Charlotte Department of Transportation

Memorandum

Date: May 1, 2008

Subject: Rezoning Petition 08-088: Located on the southwest corner of south Boulevard and East Carson Boulevard

REVISIONS:  
DATE: 03/24/08  
DESIGNED BY: RIP  
DRAWN BY: CRP  
CHECKED BY: CRP  
O.C. BY: RIP, CHK  
SCALE: 1"=30'-0"  
PROJECT #: 1007332  
SHEET #:  
**Z-1.0**

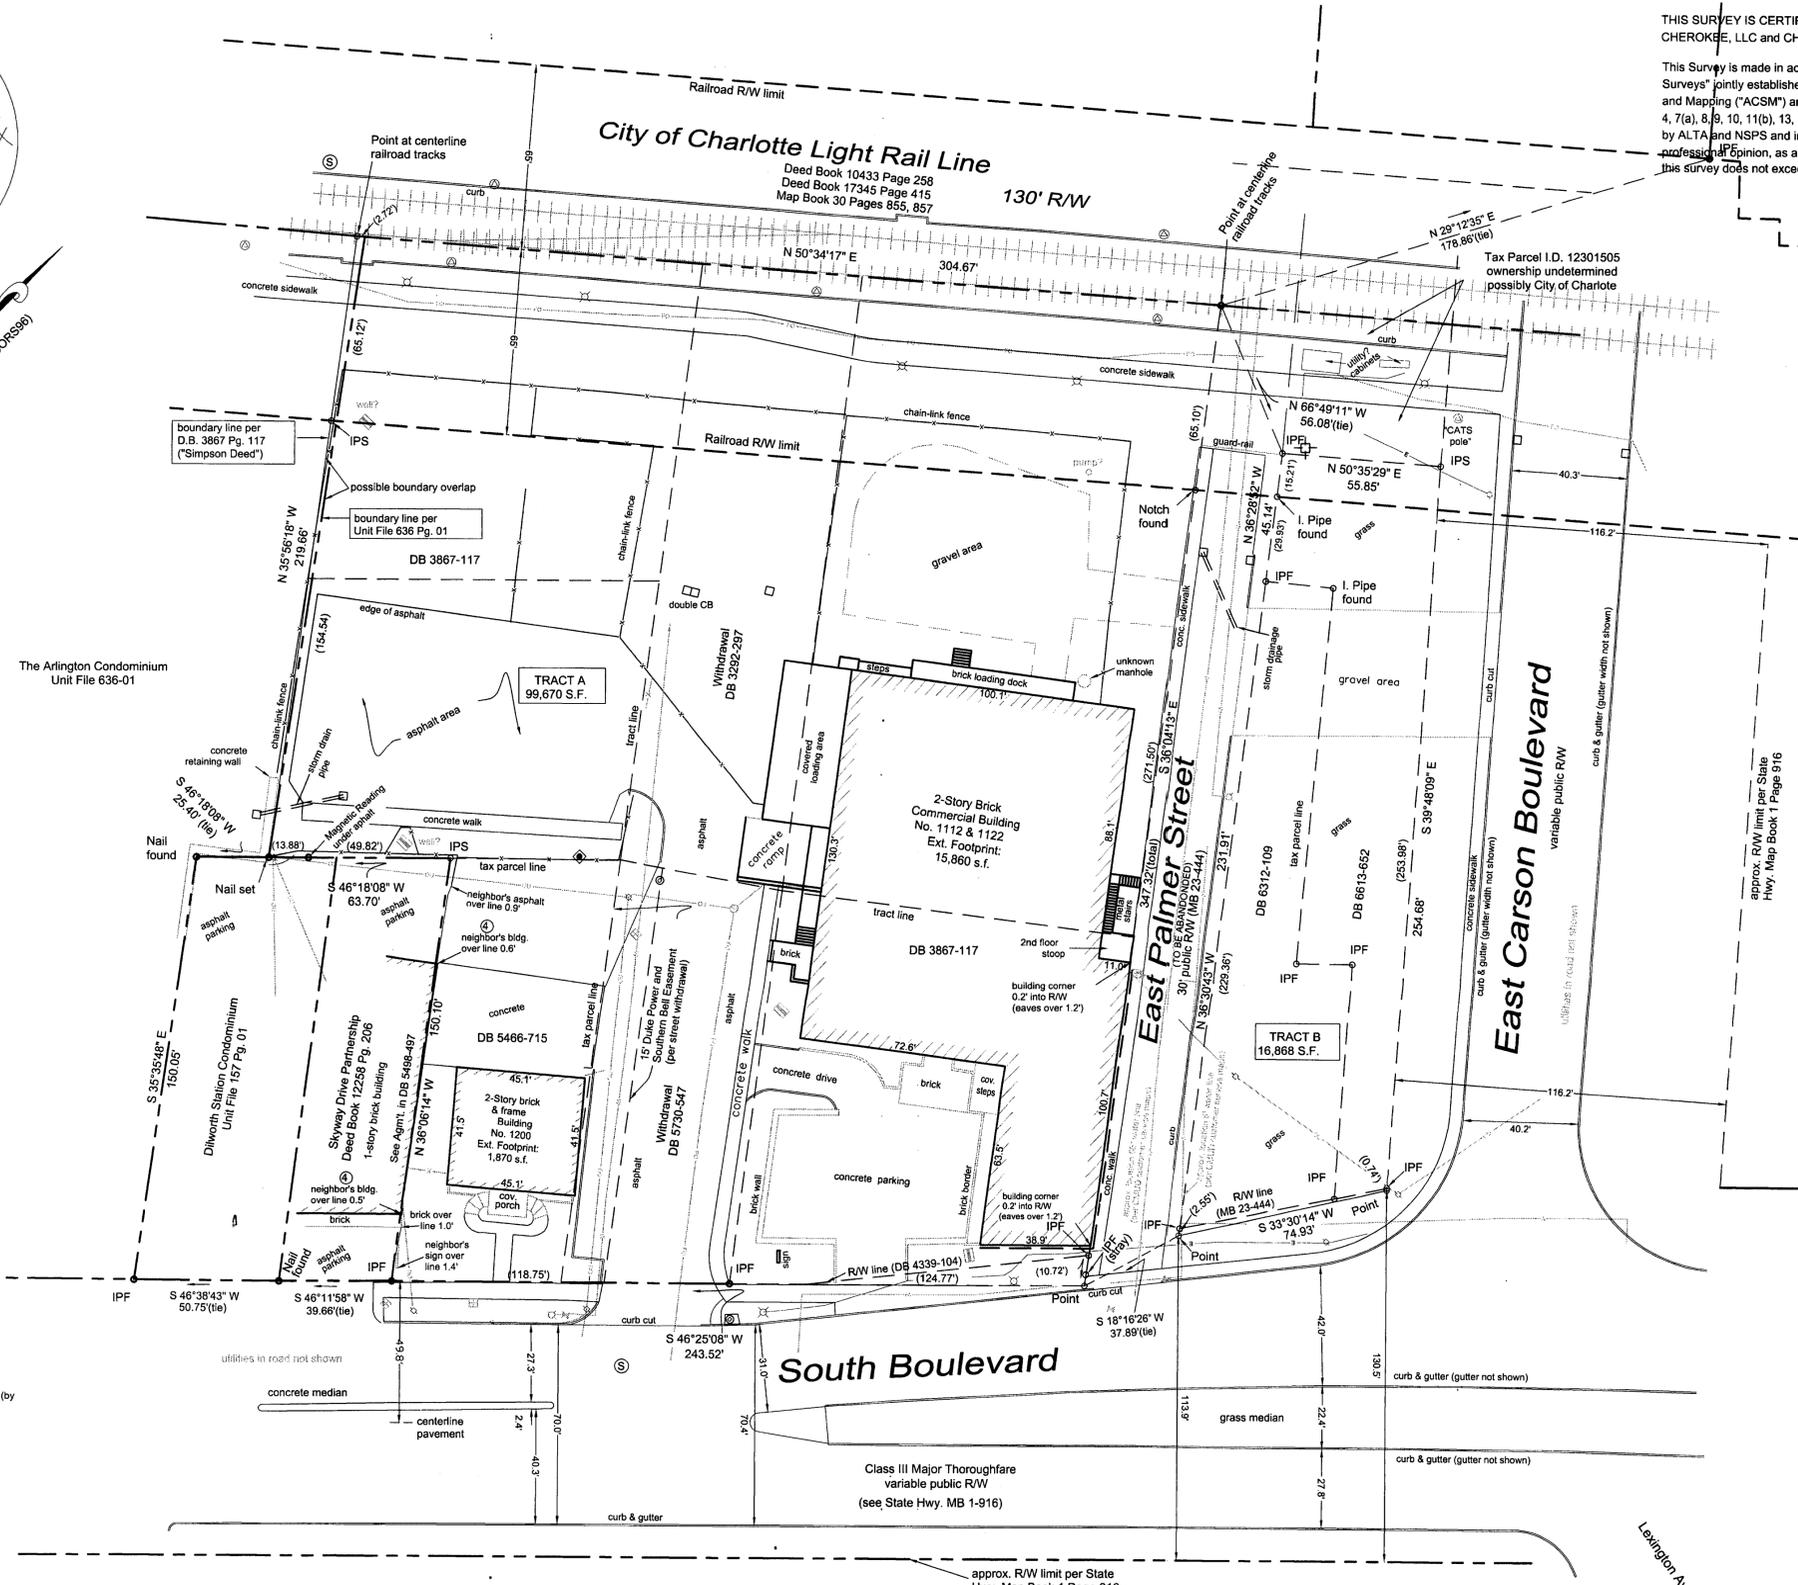
1. The developer needs to reconstruct the median and remark the section of South Boulevard between the Arlington Avenue/South Caldwell Street and Carson Boulevard/Lexington Avenue intersections as necessary to accommodate left-turn movements at the proposed full movement access driveway (approximately 40 feet east of the site's western property line. This work will require modifications to the existing concrete median, left-turn storage lengths, and bay taper lengths at several locations to meet both NCDOT/CDOT standards. The developer is responsible for the design, construction, and pavement markings associated with the improvements. These items should be noted on the site plan and will be reviewed during the commercial building permit process.

4. The developer needs to align the proposed full access driveway on East Carson Boulevard with an existing driveway on the north side of the street serving the Time Warner employee parking lot. The current site plan notes that this existing driveway is to be "realigned" by the developer. The relocation/modification of this driveway needs to include aligning it with the proposed driveway on the south side of East Carson Boulevard.

5. We request that the developer consider adding protected (recessed) on-street parallel parking on South Boulevard by relocating the existing curb.
6. The developer needs to provide additional right-of-way and/or setback to accommodate a 5-foot bicycle lane along South Boulevard. In areas adjacent to on-street parallel parking the bike lane must be 6 feet in width.

To facilitate building permit/driveway permit review and approval, the site plan must be revised to include the following:

- Dimension width of the existing and proposed driveways.
- New/reconstructed driveways must be drop curb ramp Type II-Modified or Type III driveways, if warranted.
- Indicate the locations and widths of all adjacent and opposing driveways.
- Indicate typical parking module dimensions.
- Directional wheelchair ramps (two per corner) should be provided at all intersections of public and private streets.
- Include a parking summary with figures for the numbers of parking spaces required and provided.
- Parking deck operations and gate locations.
